From: Garry Mount [REDACTED]
Sent: 09 October 2014 16:58
To: Janice Chapman
Subject: Quince cottage - BN/32/14/HH
Attachments: 2014-26-03 Site plan-Layout1.pdf; Quince Cottage - Sketches.pdf

Re: Quince Cottage, Church Lane, Barnham.
Your ref: BN/32/14/HH

North Elevation (front)

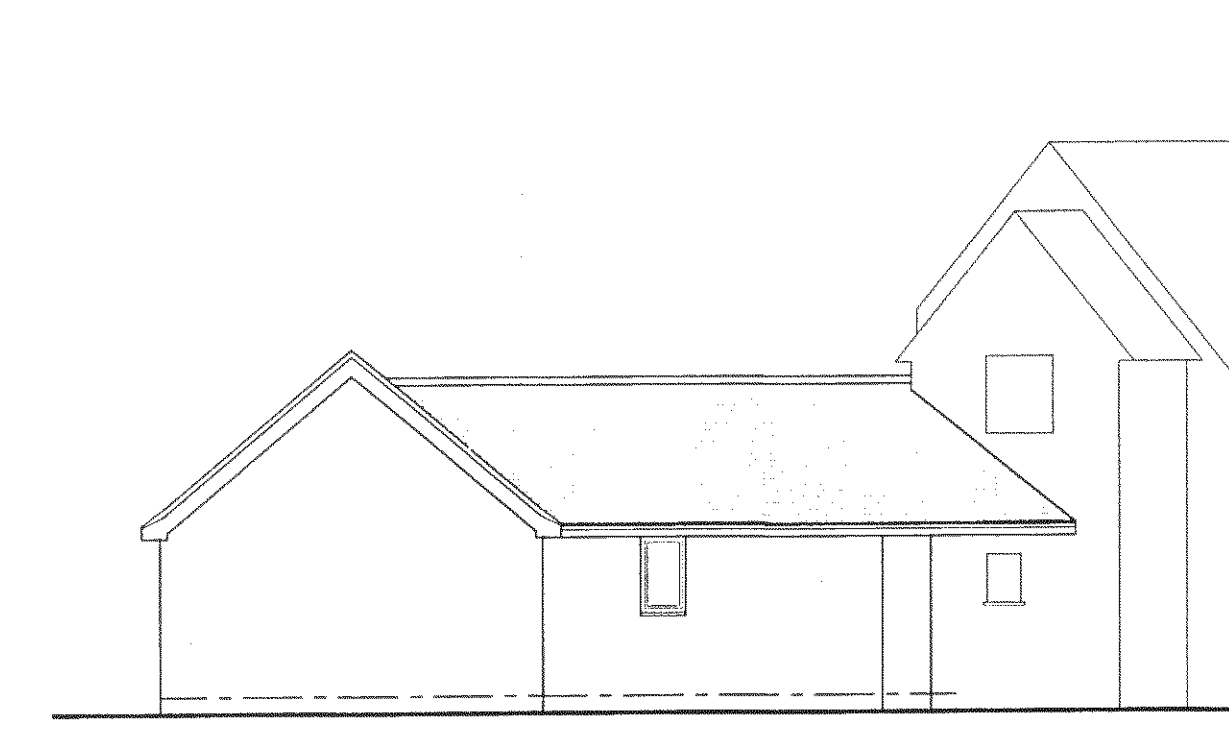
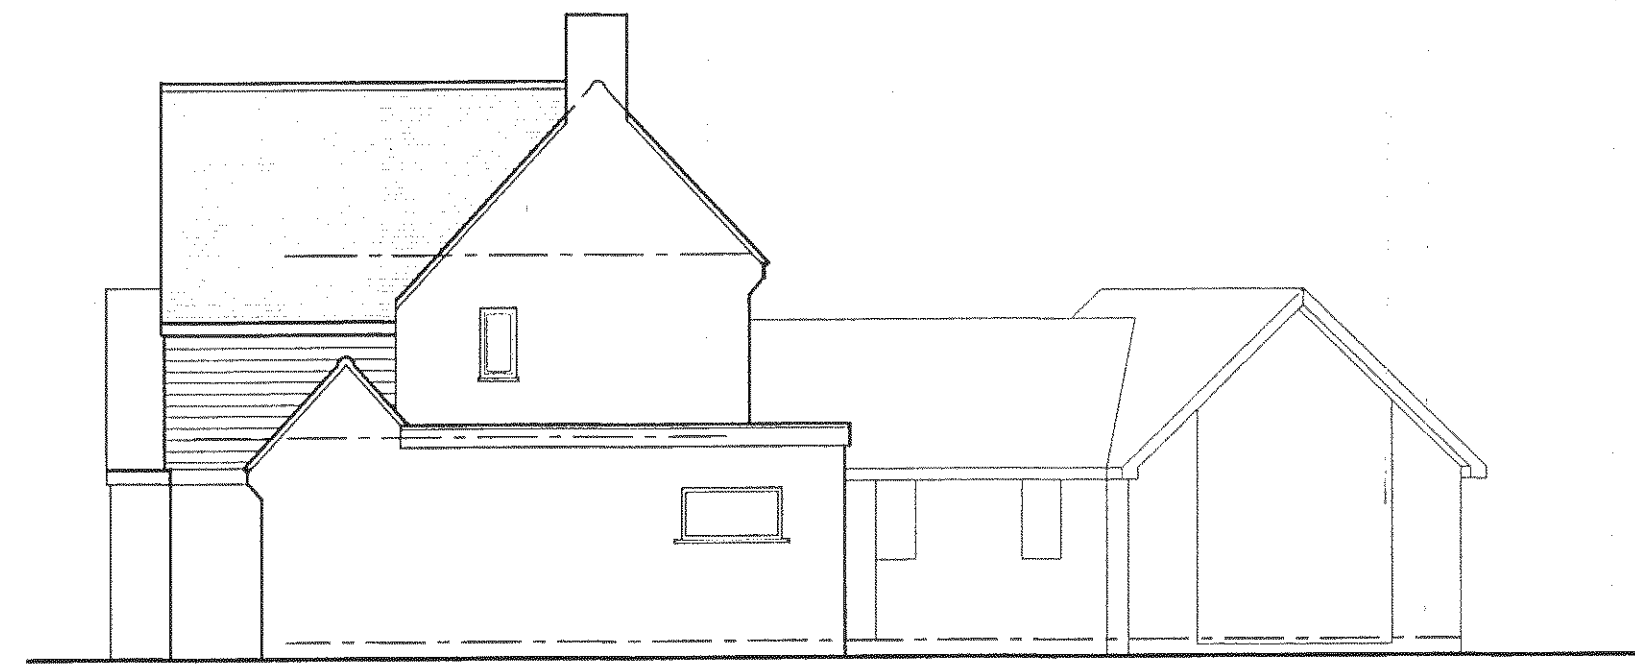
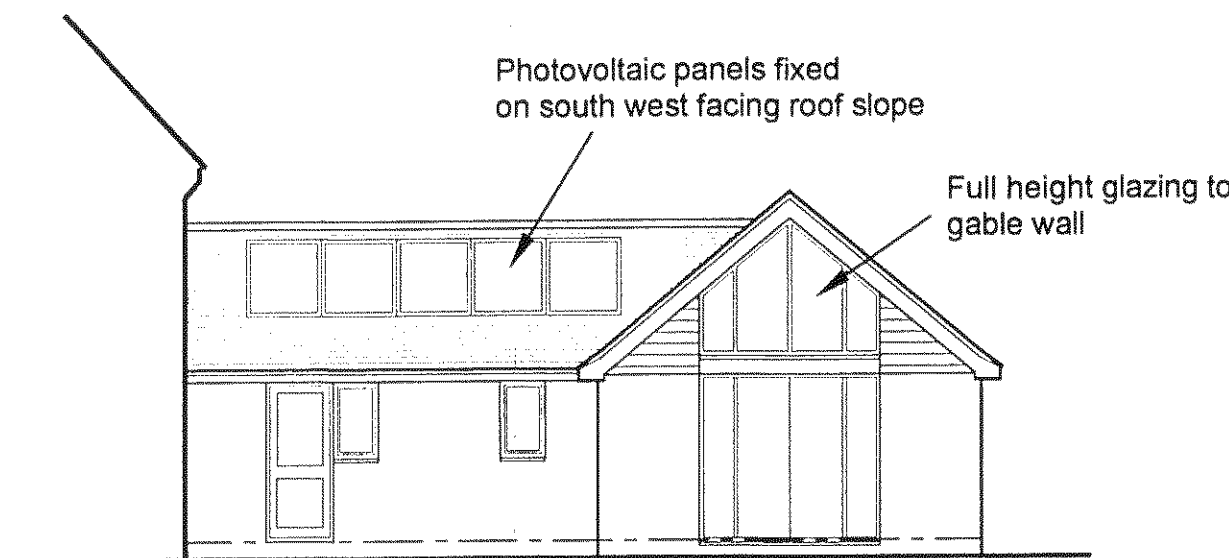
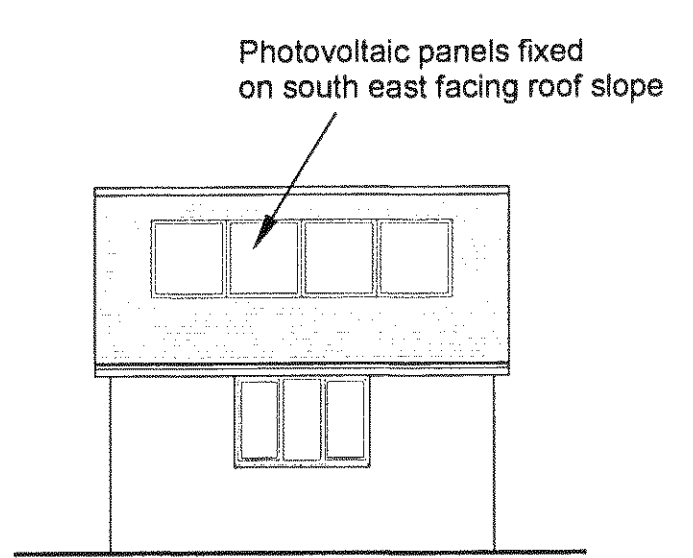
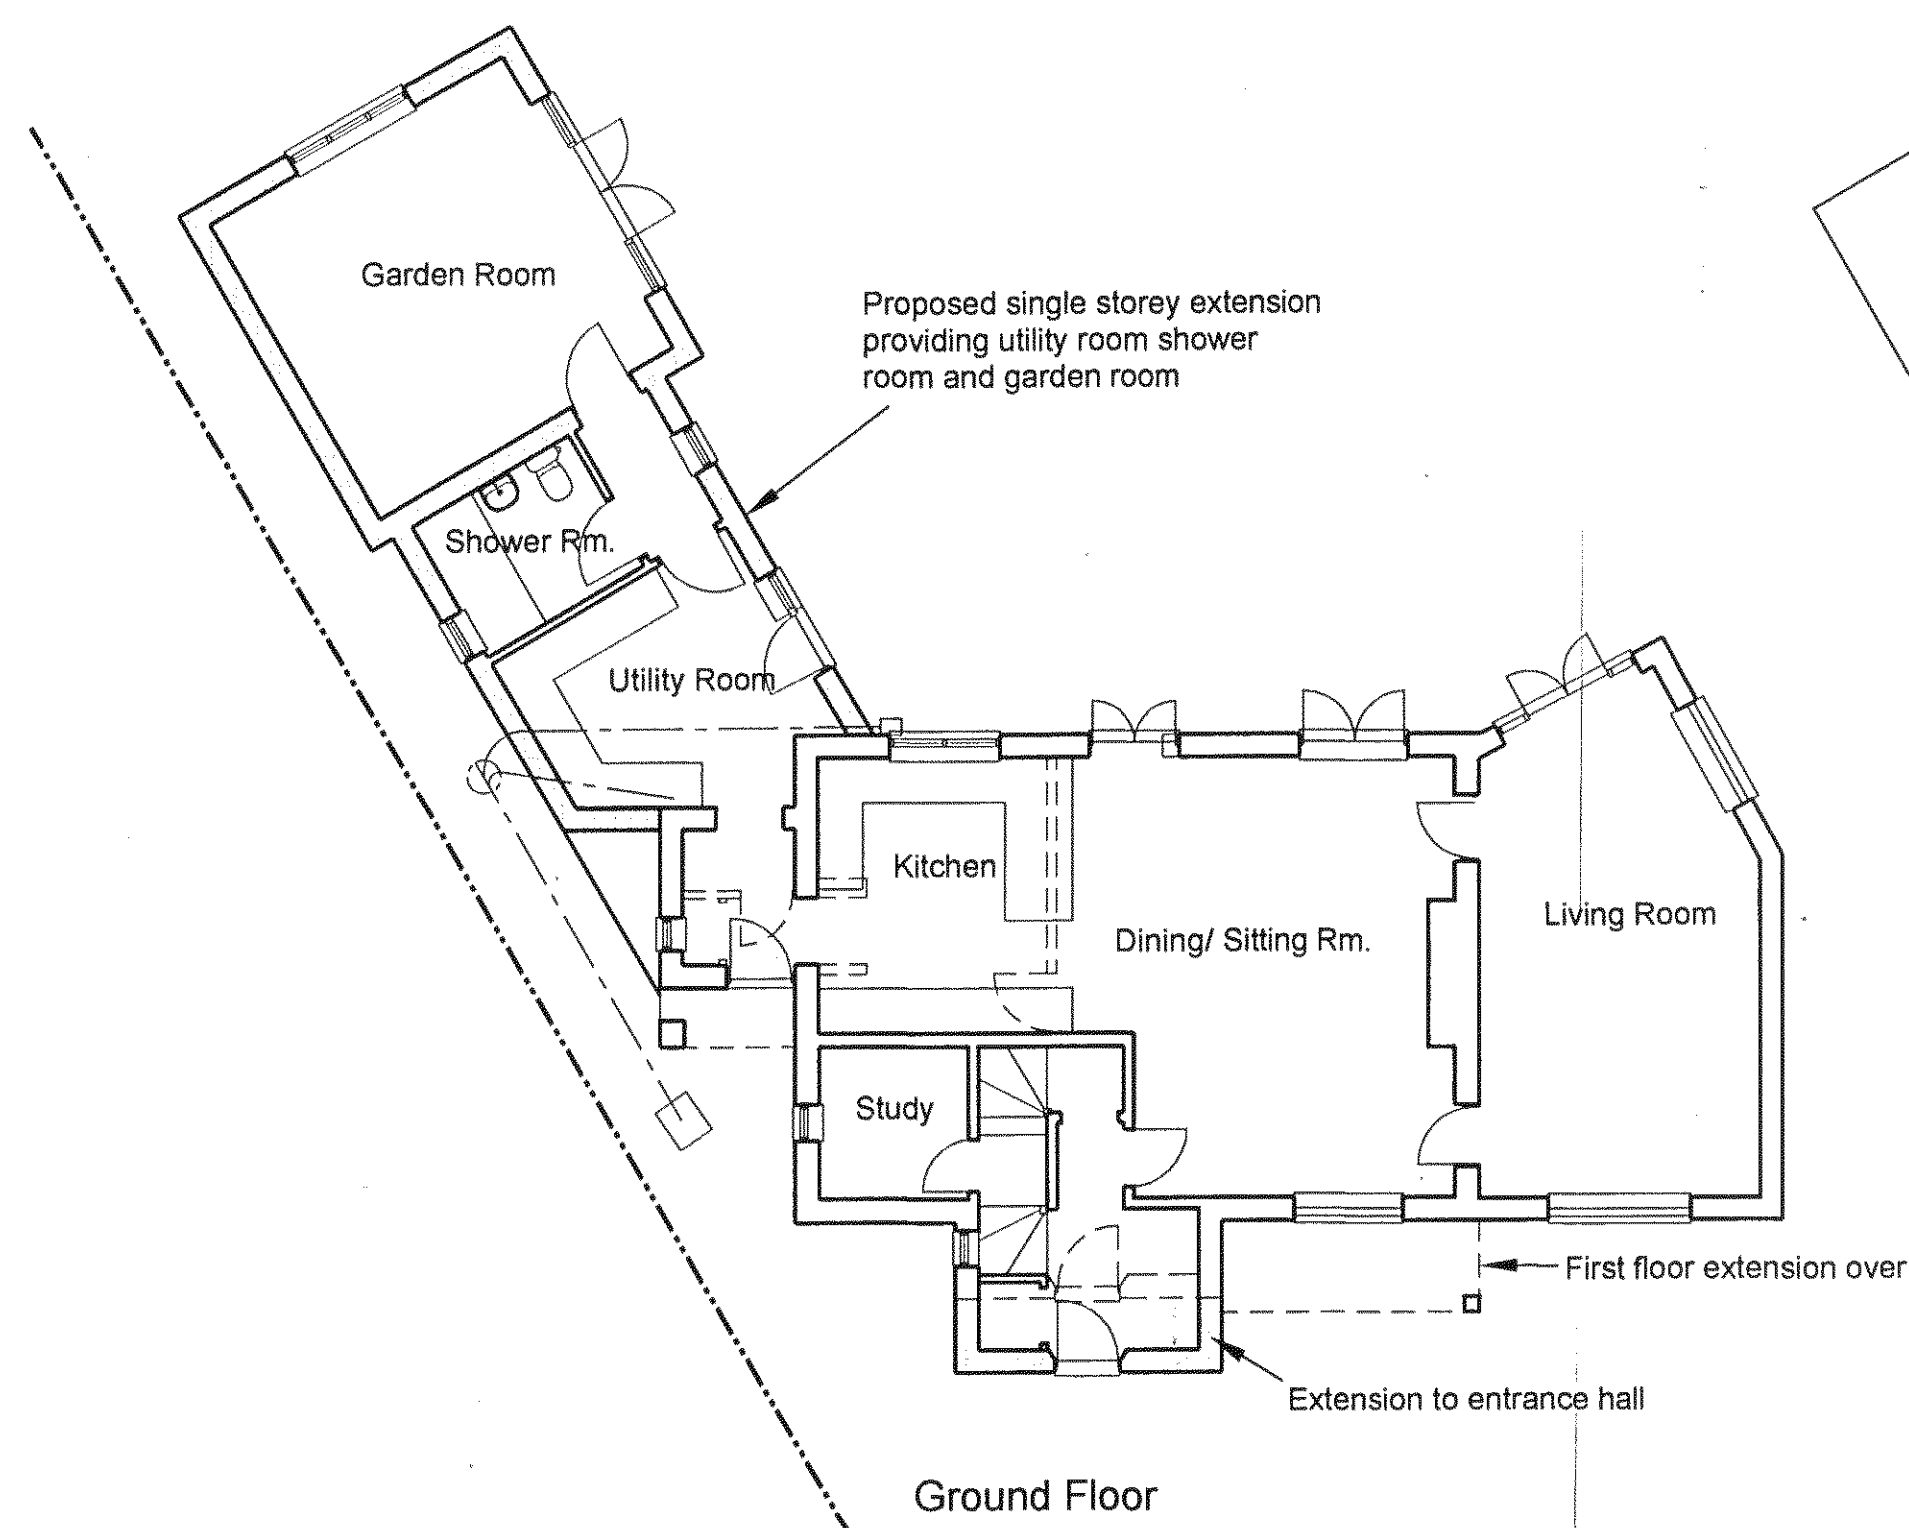
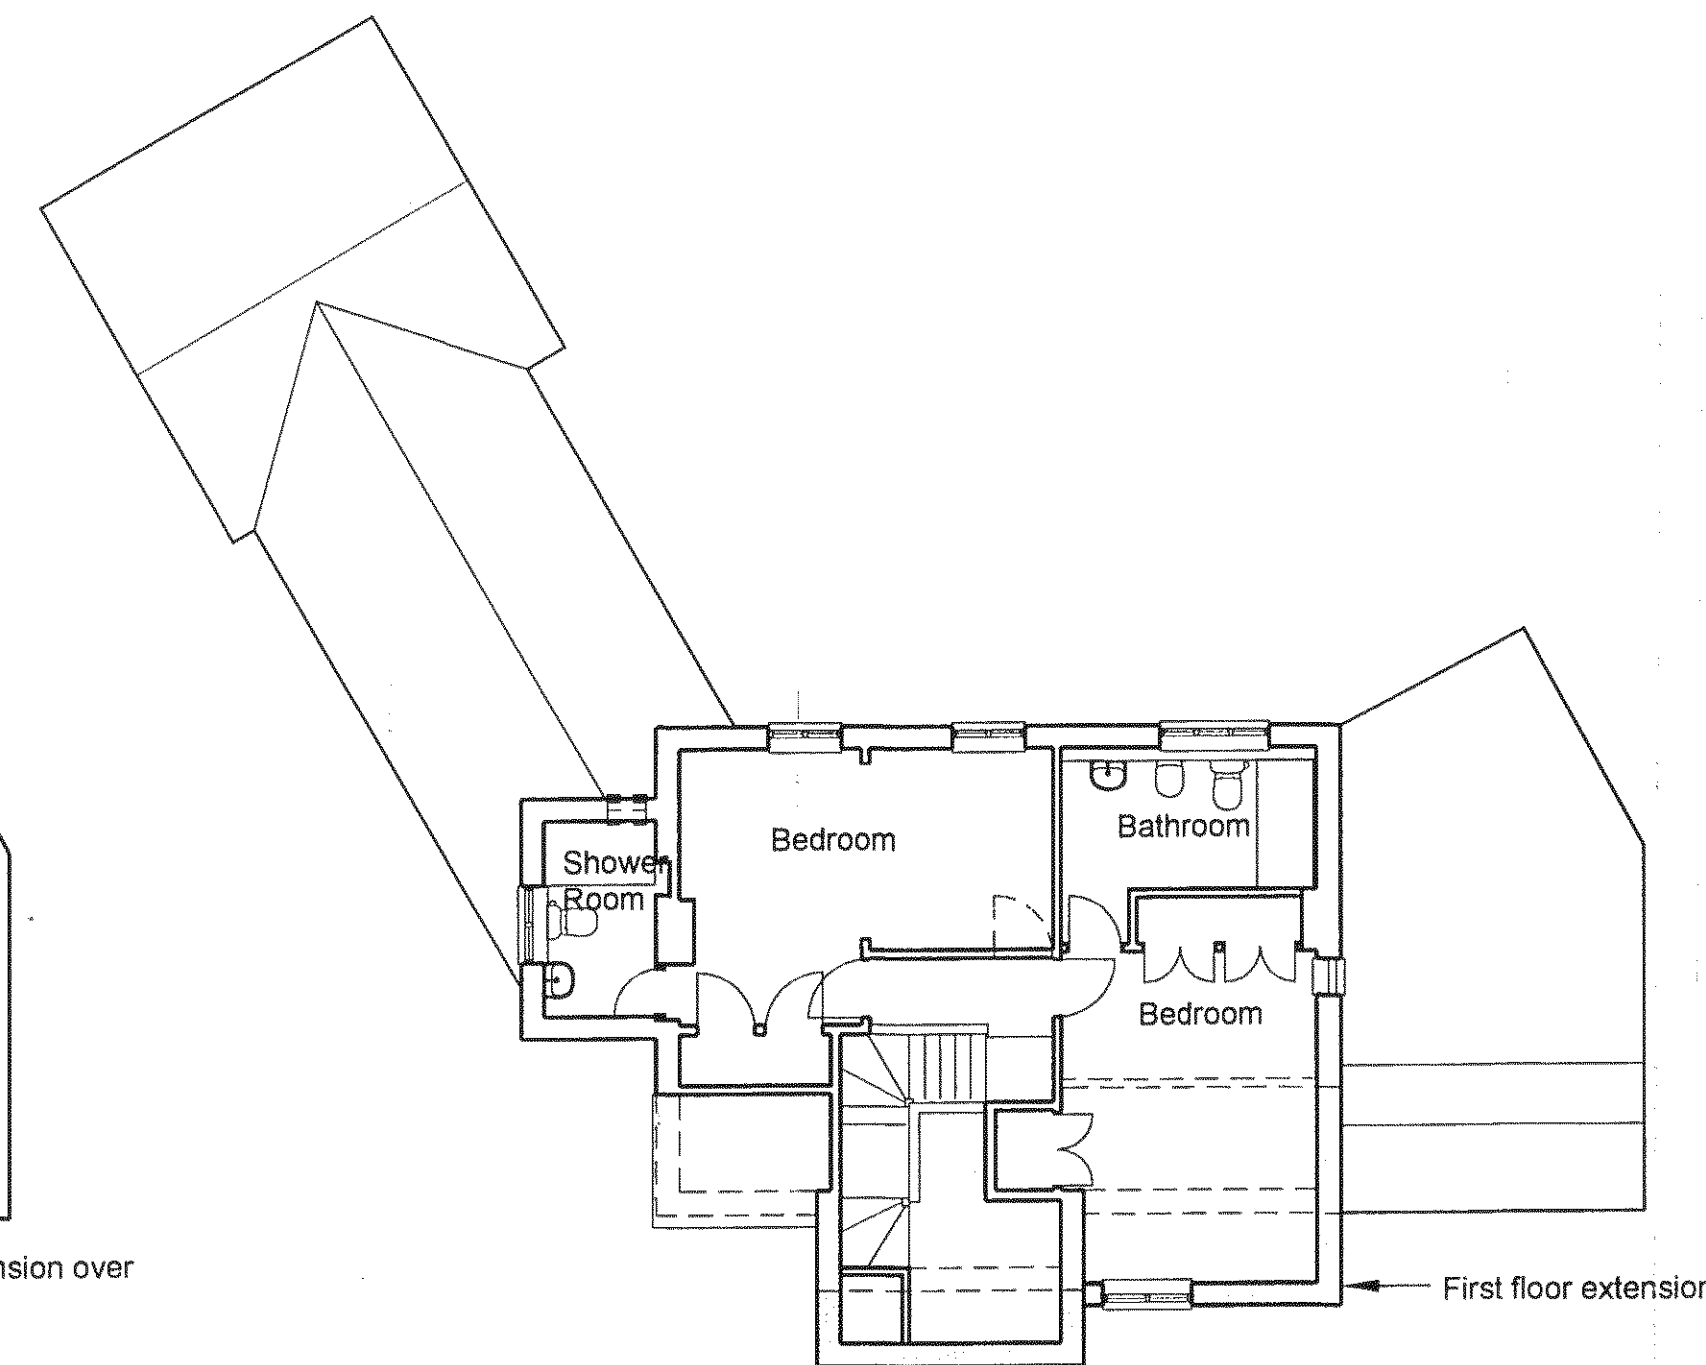
With reference to the extension to front elevation, I don't agree with Mr Vick's comment that the elevation would be unbalanced. This is not an unusual roof form, with a gable projecting from one end of a pitched roof, although not symmetrical it is a well proportioned and balances elevation. The style of the proposal is appropriate and the extension would enhance the appearance of the cottage. Currently there is a large expanse of tiled roof on the front elevation, broken up only by the projecting gable of the porch.

My original brief was to form a first floor extension over the existing single storey flat roof extension to the west elevation. Due to the orientation of the building and the boundary position the rear section of wall to the west elevation has been constructed at approximately 45 degrees to the main house. This makes it very difficult to design an extension over this area with a pitched roof. I have attached my initial sketches showing an extension over this area. I'm sure you would agree, the north elevation may be acceptable but the south and west elevations would not be.

We feel that current proposal is in keeping with the original cottage and enhances the front elevation.
